From: Paul Cann
Sent: 27 February 2018 16:47
To: Planning.Responses
Subject: RE: Planning Consultation on WA/11/18/DOC

Site Address: Progress Garage Yapton Lane Walberton BN18 0AS

Description of Works: Approval of details reserved by condition imposed under WA/29/17/RES relating to conditions 3-schedule & samples of materials & finishes, 4-surface water drainage, 5-maintenance manual & details of SUDs, 7-cycle parking, 8- site set up during construction & 9-scheme to deal with risks of contamination.

DETAIL OF PRECAST CONCRETE PERFORATED RING SOAKAWAY (DEPTHS LESS THAN 3.0m)
(Scale 1:20)

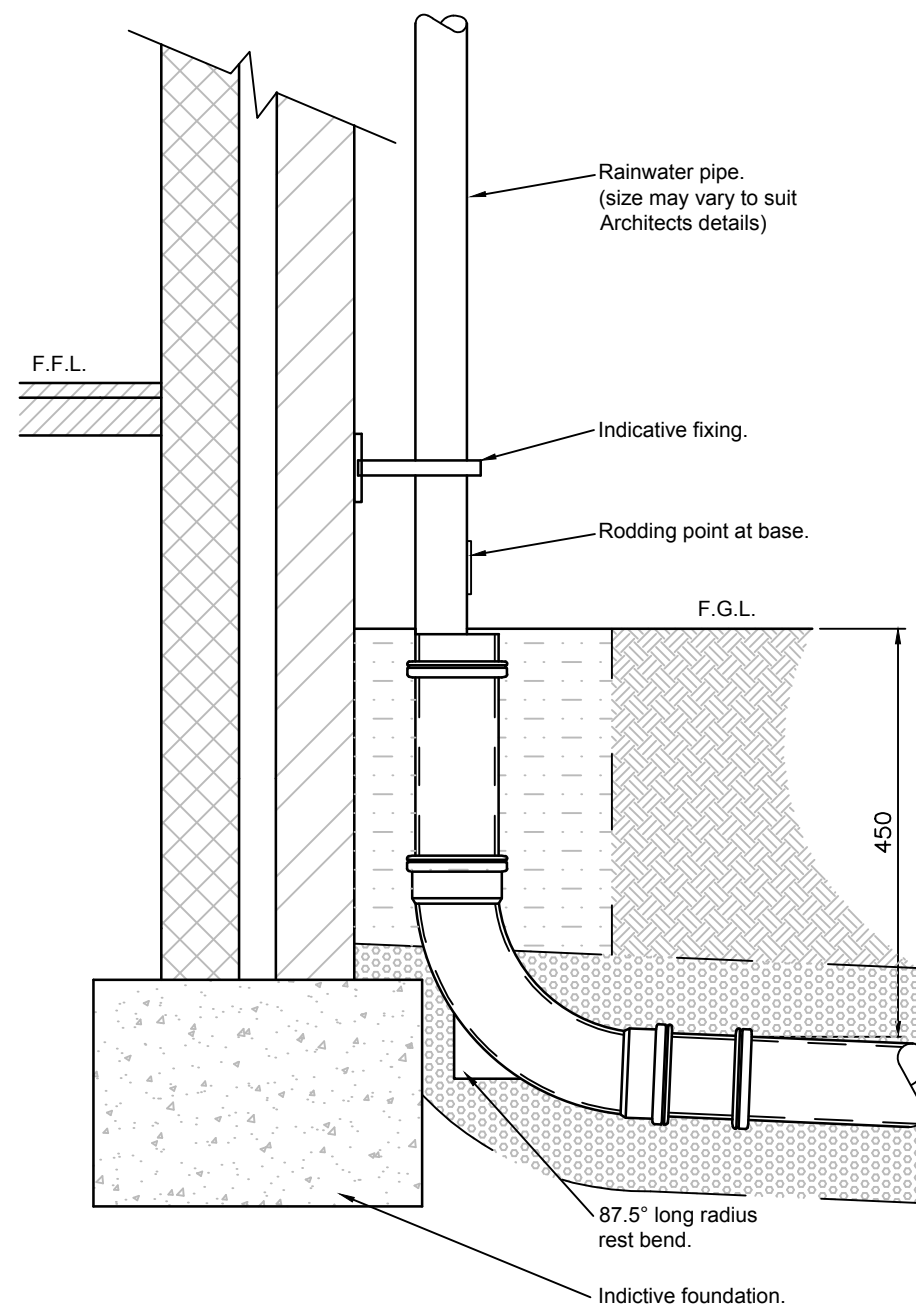
1. Winter groundwater monitoring data and winter percolation testing data to BRE365 has not been supplied. Groundwater monitoring was carried out in April 2017 but this is outside the recognised winter period. These aspects are critical to the design, and the proposals cannot therefore be considered further until such time that the data is available and been considered.
2. Full construction details for the drainage elements will also be required, together with hydraulic calculations to ensure the 1 in 100 year storm event + climate change allowance can be stored within the system.
3. The drainage layout will need to include all relevant levels ie. finished surface levels/permeable paving base levels/pipe invert levels/pipe diameters/Pipe gradients/manhole cover levels, etc.
